THE HILLS SHIRE COUNCIL

Our Ref: 56/2024/PRE
Your Ref: PAE-97925968
SSD-76190964

**Build-to-Rent Housing, Co-Living Housing and Commercial Development
Lot 19 DP 280013, Tempus Street, Rouse Hill (Rouse Hill Town Centre)**

Basement 1 Plan

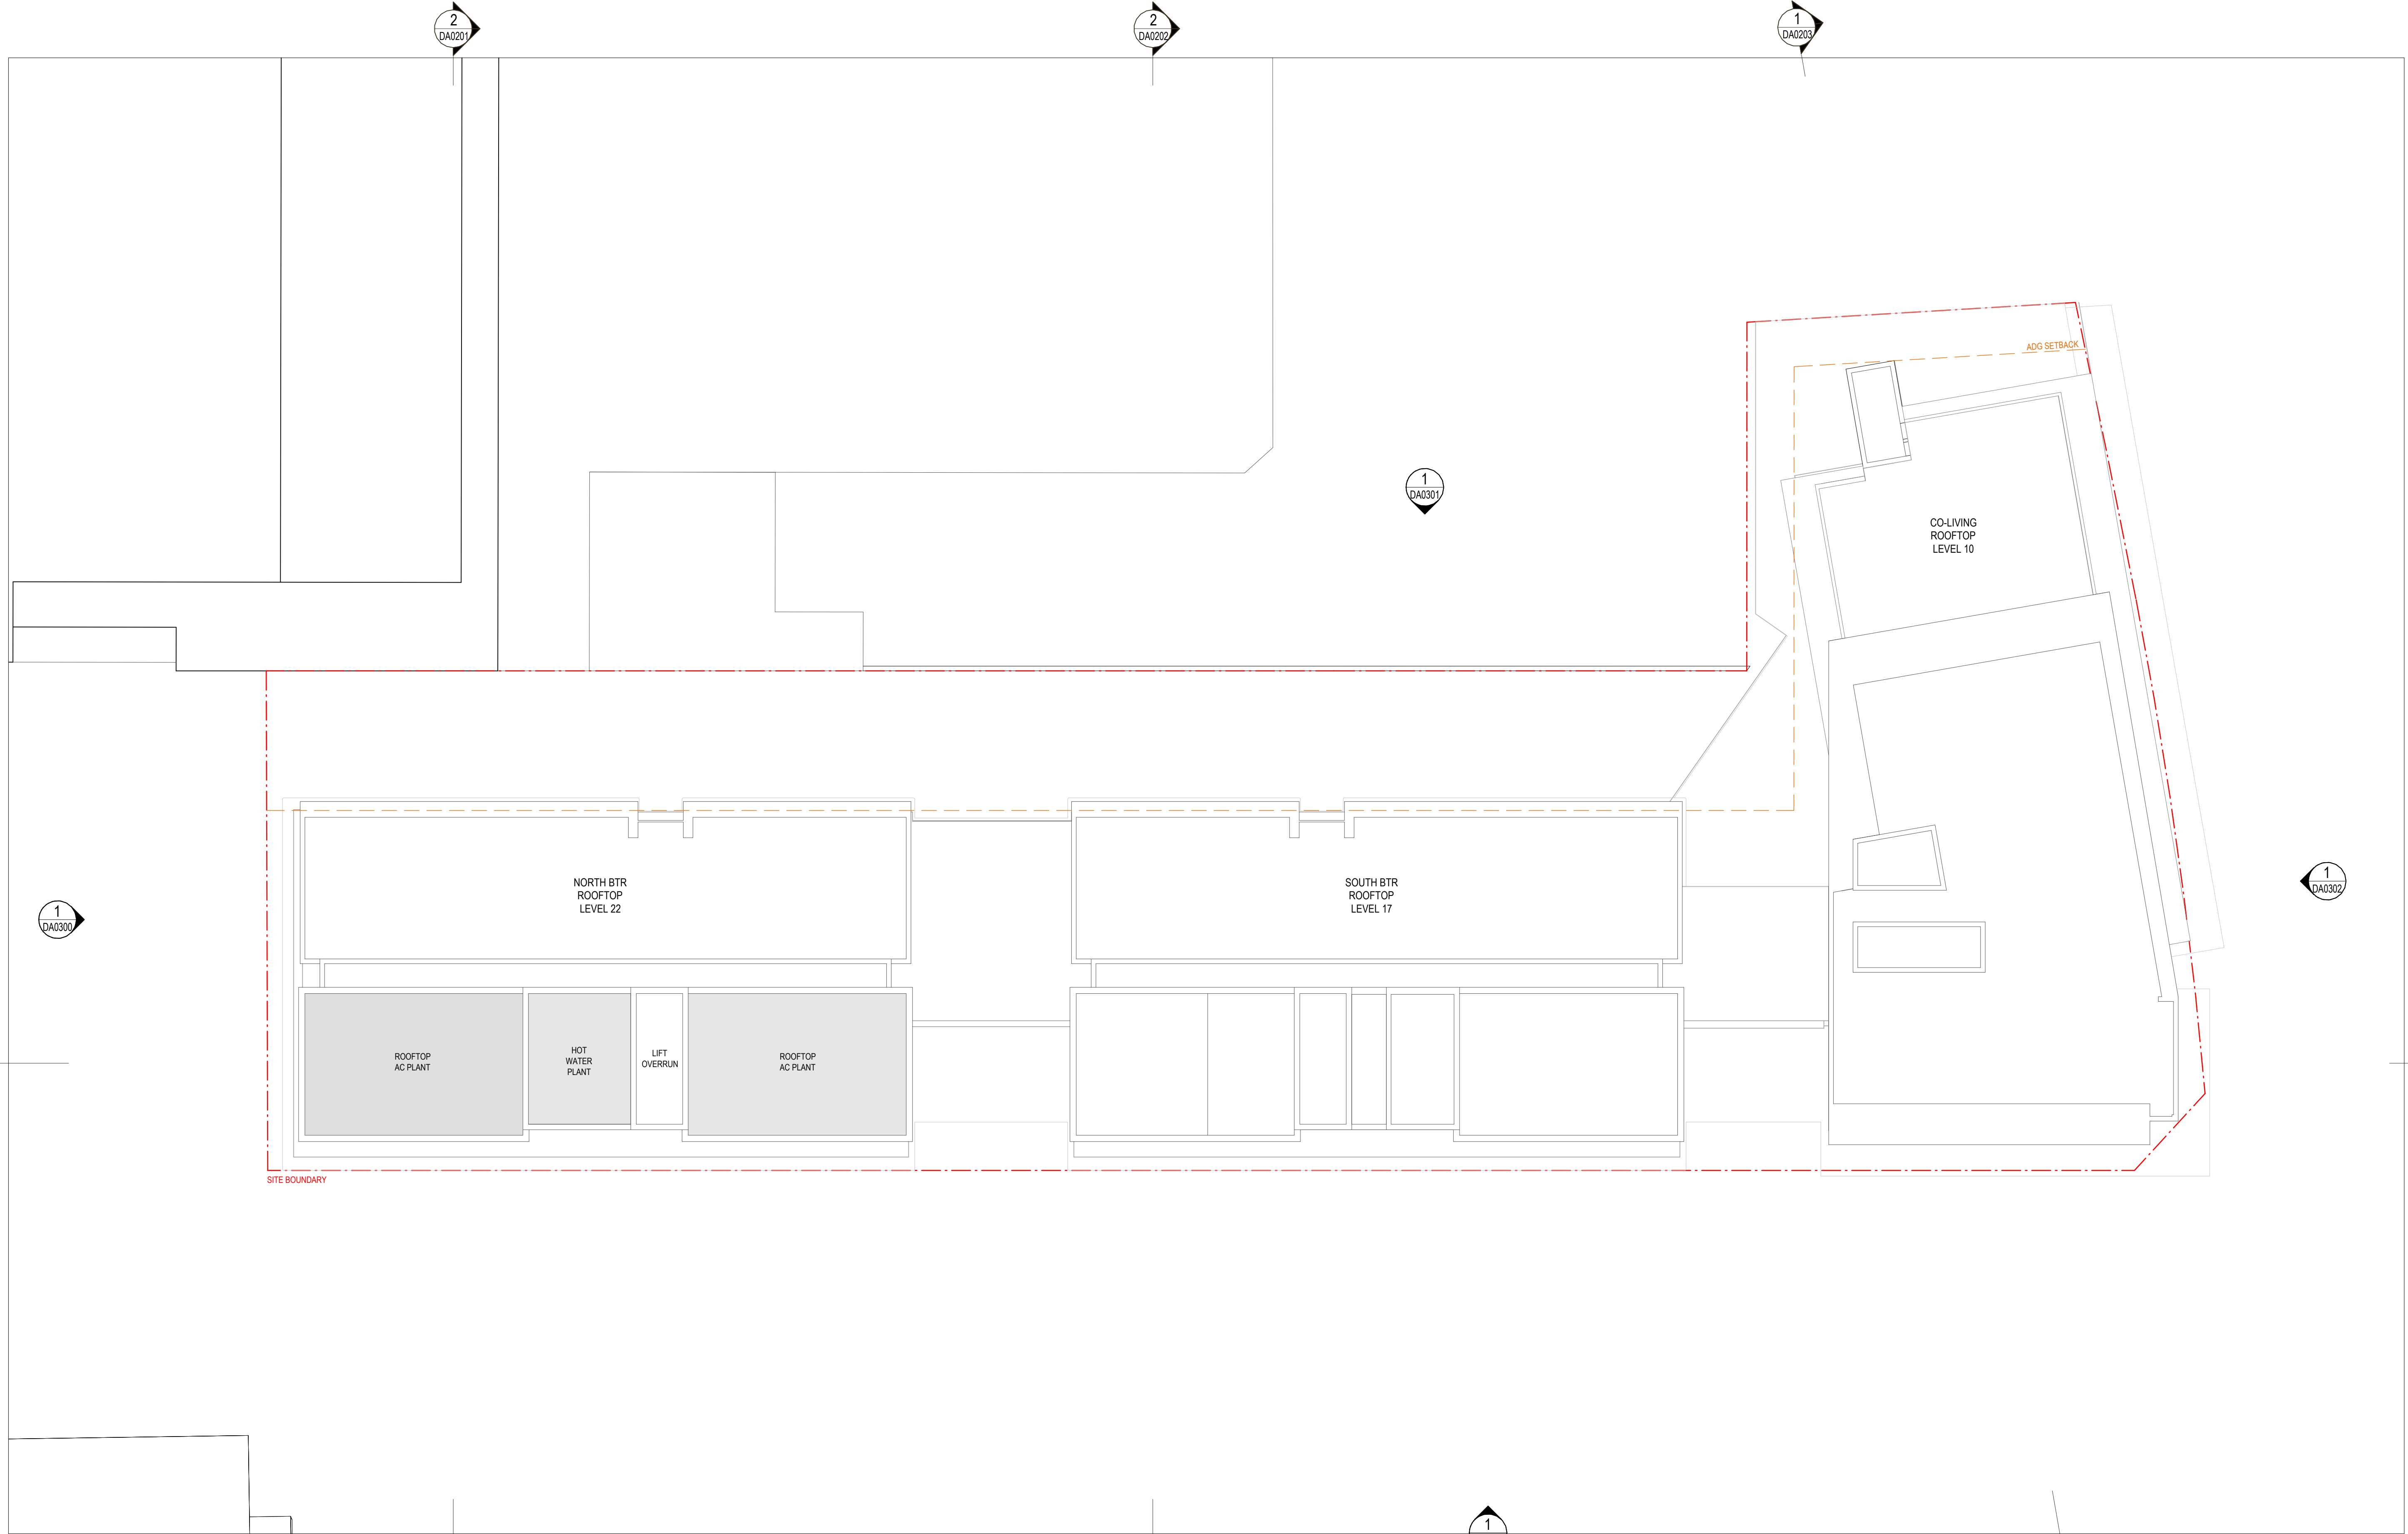
- a. The size and the location of the turntable is not suitable and cannot be supported.
- i. The 12.5m long Heavy Rigid Vehicle overhangs at both ends when parked at the turntable. This has potential for the truck to conflict with cars parked in the car parking spaces directly adjacent to the turntable when in operation (turning around).

- ii. When a waste collection vehicle is parked at the turntable and collecting bins it blocks access to a significant number of car parking spaces behind the turntable. This is noted as a significant concern as the scale of the development requires intensive waste collection frequencies.

It is strongly recommended that a redesign is implemented to provide a loading bay that is located off the internal driveway aisle ensuring the standard 12.5m long HRV (AS2890.2) does not impeded internal traffic or parked cars. Ideally, for a development of this scale, separate loading bays (sized for the 12.5m long HRV) for the residential and commercial collection vehicles are to be provided, however given the limited constraints of the site, the implementation of a Loading Dock Management Plan may be supported as long as it can be confirmed that Council's waste collection vehicles will be prioritised to ensure residential bins can be safely collected. Residential waste collection may occur anytime between 5am-5pm on the scheduled collection days. Specific times cannot be guaranteed.

Drawing Number
24378-RBG-XX-XX-DR-CV-83101

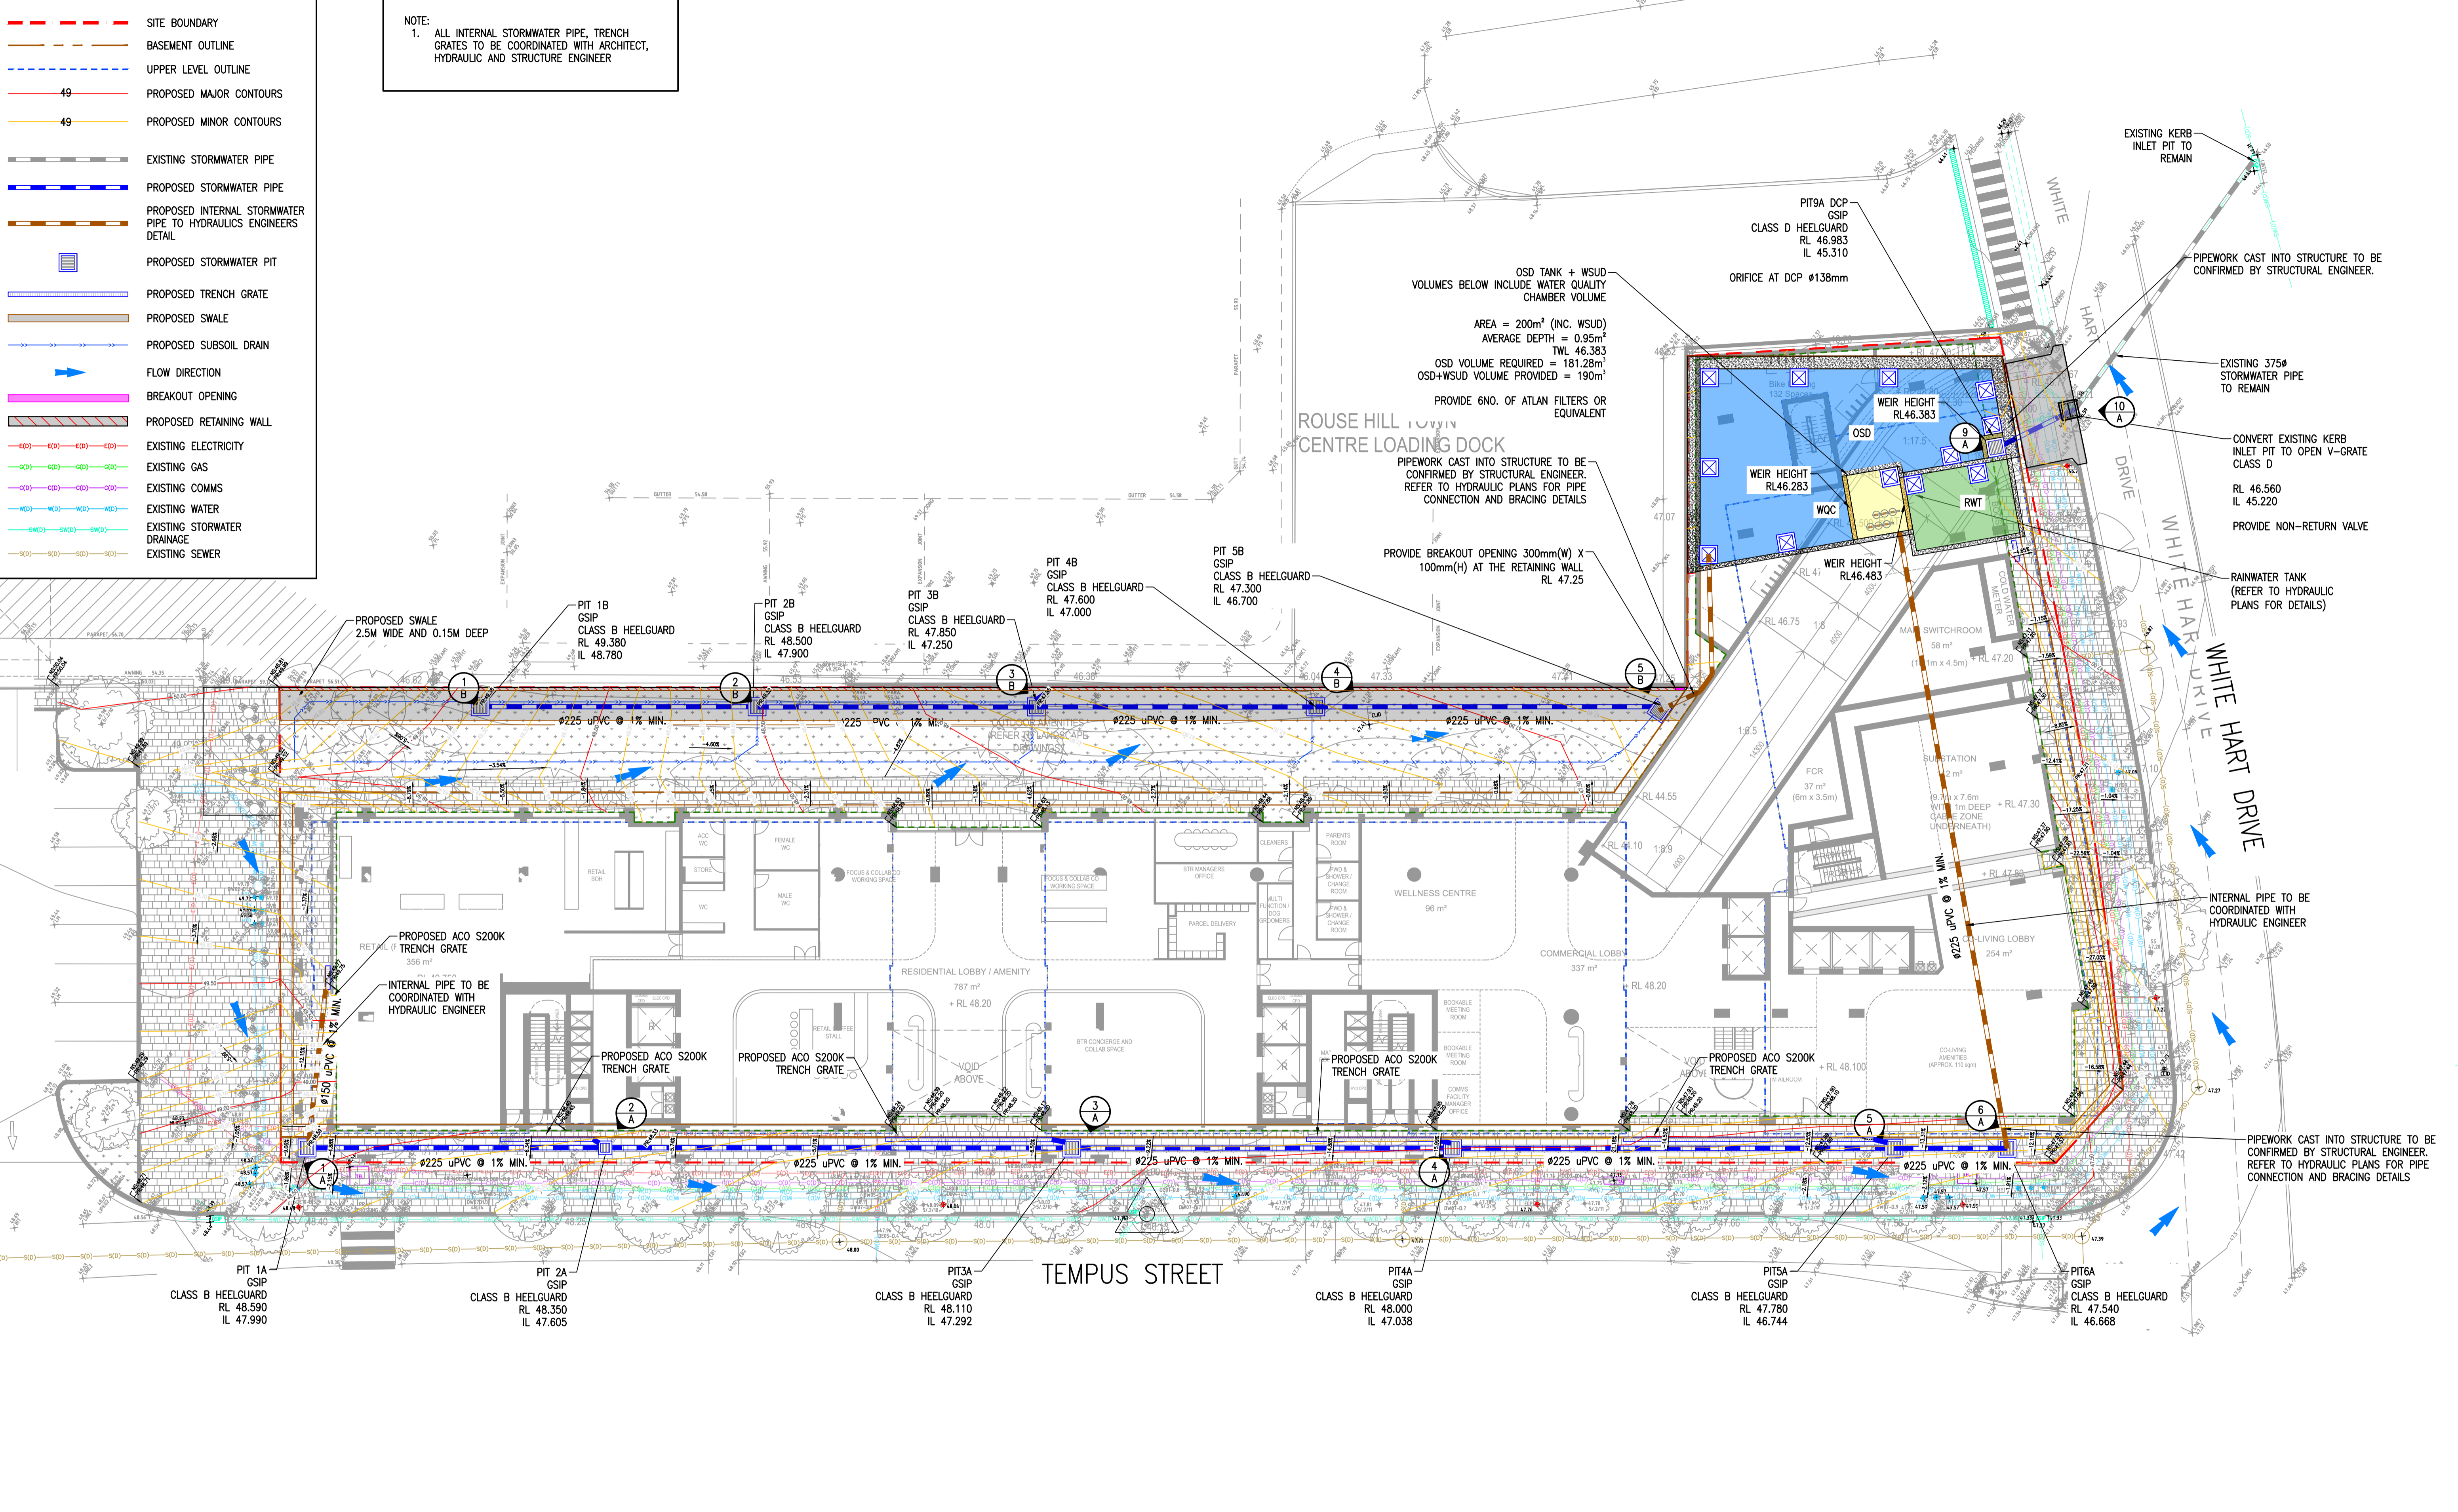
- a. A stormwater report is required detailing the stormwater strategy for the development. The strategy is to be reflected on the stormwater plans.
- b. The capacity of the existing stormwater to which this development discharges into must be checked/ analysed. The street pit is not to surcharge for all minor events up to the 10 years ARI and up to the 20 years ARI for a sag pit.

- c. OSD details such as cross section plans, Discharge Control Pit details, top of water levels etc. is to be provided on the stormwater plans along with calculations comply with the Upper Parramatta River Catchment Trust Handbook (UPRCT) parameters for the Hawkesbury Catchment. The OSD will need to be designed for the drowned condition.
